DEVELOPMENT APPLICATION ASSESSMENT REPORT

CARWASH FACILITY

130 Cormorant Road, Kooragang

DA 6988

Approved	Designed
Date 2nd OCTOBER 2014	Drawn AST
Scale 1:200 @ A1, 1:400 @ A3	Checked
Project No. 14 - 056	Drawing No. A - 01
	Andt. DA-4

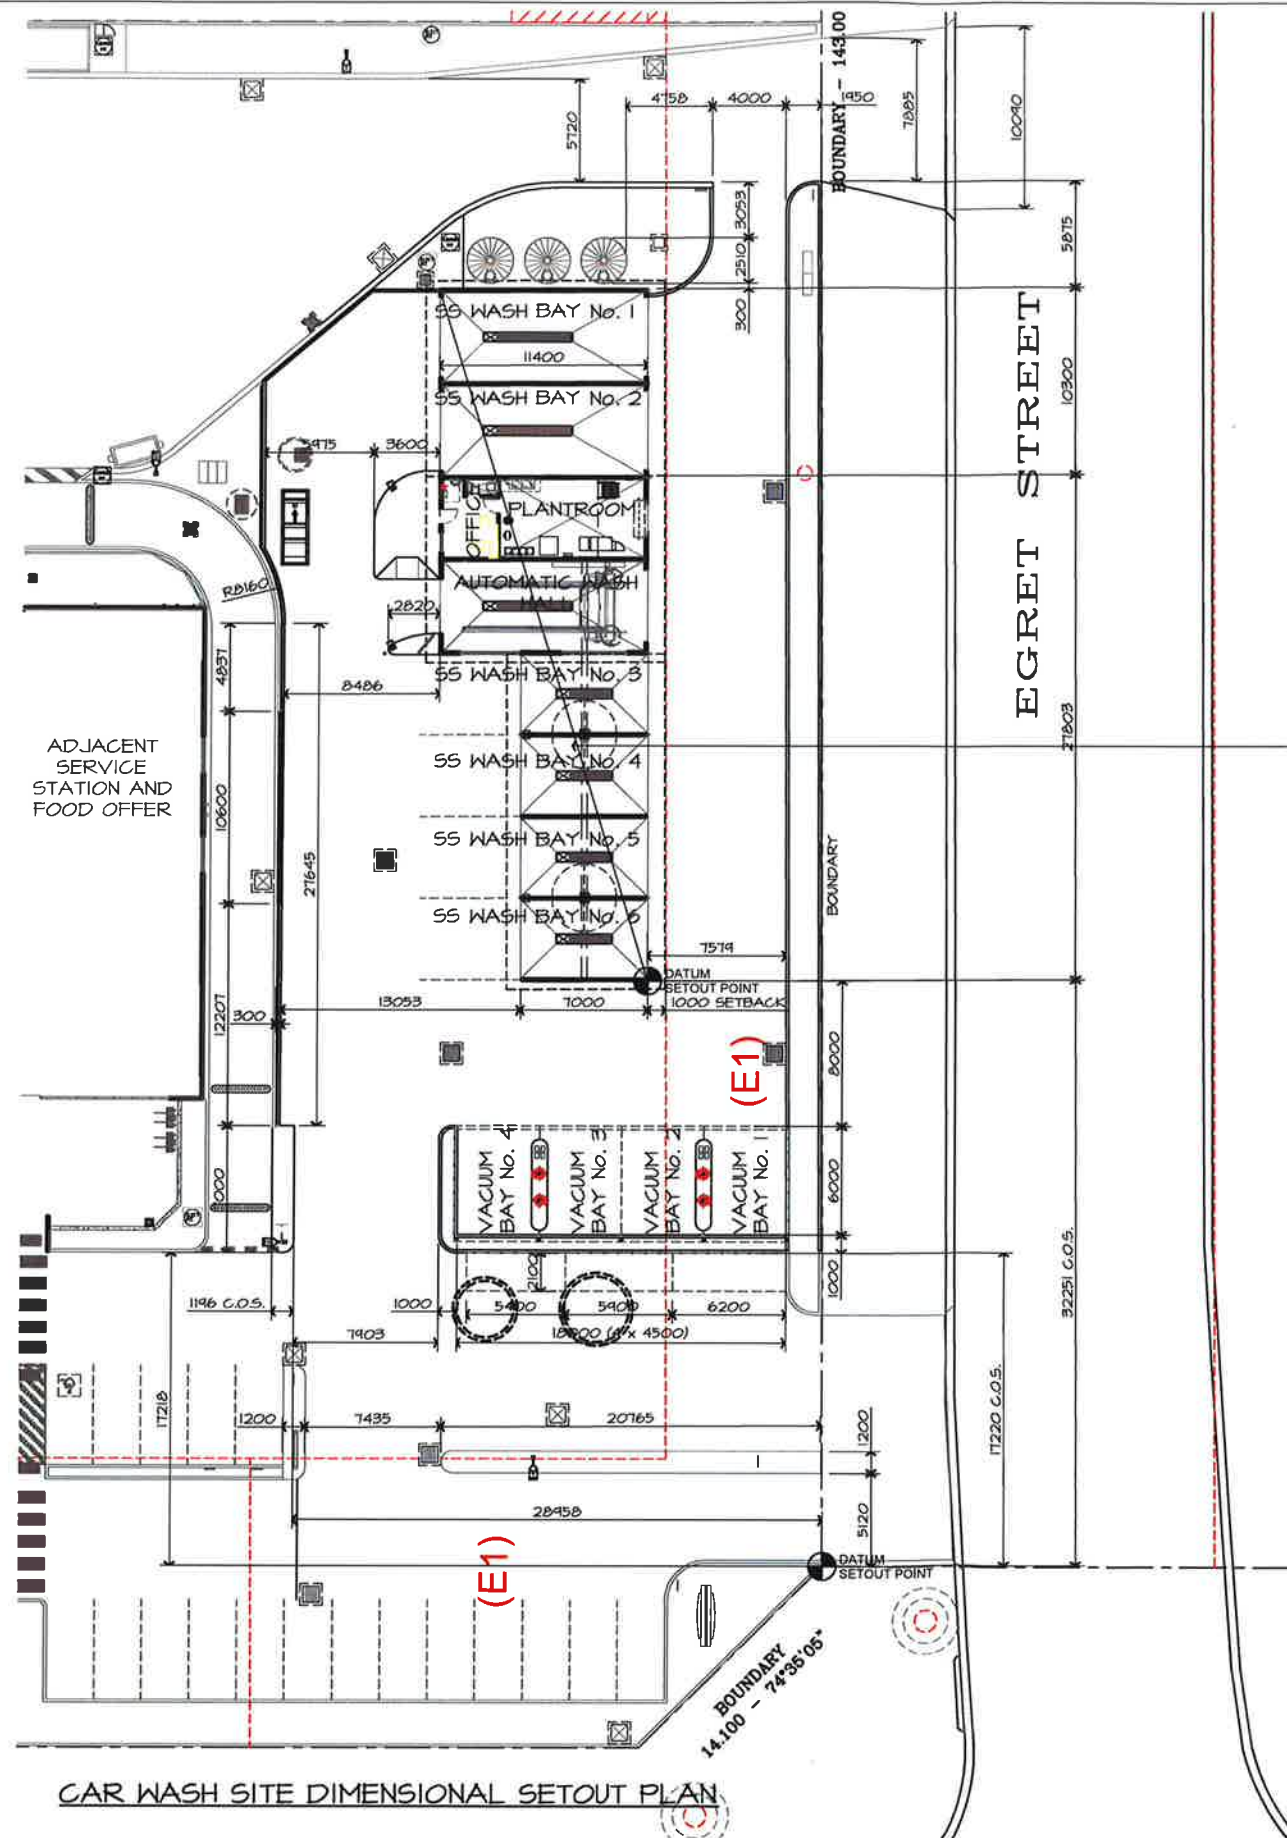
RMS and Council did not object to the proposal. However, both raised concerns about the original location of the carwash entry on the south-eastern end of the proposed development (shown in **Figure 7**). In particular, RMS noted that vehicles wishing to access the proposed development from Egret Street may queue onto Egret Street due to cumulative traffic movements from the service station and food outlet. The Department held a meeting with RMS and Council to determine an appropriate solution. It was agreed that to reduce the potential for queuing on Egret Street, the carwash entry should be moved to the south-western end of the proposed development and away from the southern driveway (see **Figure 7**). Furthermore, it was agreed that a physical barrier and associated directional signage should be installed on the southern driveway to improve traffic safety on-site and minimise the potential for conflict.

Council also identified a potential safety issue regarding vehicles exiting the proposed development onto the northern driveway. The northern driveway is to be used by heavy vehicles leaving the service station. Council noted that the rainwater tanks positioned at the northern end of the carwash building could obstruct the driver's view of heavy vehicles already on the northern driveway. In response, the Applicant agreed to move the exit 3m northward, although it would reduce the width of the northern driveway from 10m to 7m wide (See **Figure 7**). However, this would not alter the width or operation of the northern driveway approach onto Egret Street. The Applicant also confirmed that it would install a 'Stop' sign and pavement markings at the carwash exit to ensure vehicles exiting the proposed carwash development give way to other vehicles already on the northern driveway. Council was satisfied and did not raise any other issues.

The Applicant agreed to the movement of the carwash entry and redesign of the southern driveway to include a concrete median strip to separate opposing traffic. The Applicant also committed to installing directional signage on the driveway including two 'give way' signs to be located adjacent to the carwash entry for traffic exiting the site, a 'keep left' sign on the concrete median strip and a 'no exit' sign at the entry point off Egret Street. RMS and Council were both satisfied with this approach.

The Department reviewed the Applicant's updated site layout and access plan and is satisfied that the new carwash entry, type of physical barrier and directional signage addresses the potential traffic safety issues and conflicts on the southern driveway, particularly queuing onto Egret Street. As such, the Department has included a condition to reflect these vehicle access requirements and to require these physical works and signs to be installed prior to the commencement of operation.

The Department considers that moving the carwash exit further north does not impact on the operation of the northern driveway for heavy vehicles and addresses the safety issues raised by Council by improving the driver's line of sight when exiting the development. The Department has included a condition for the Applicant to install a 'stop sign' and associated pavement markings at the carwash exit.
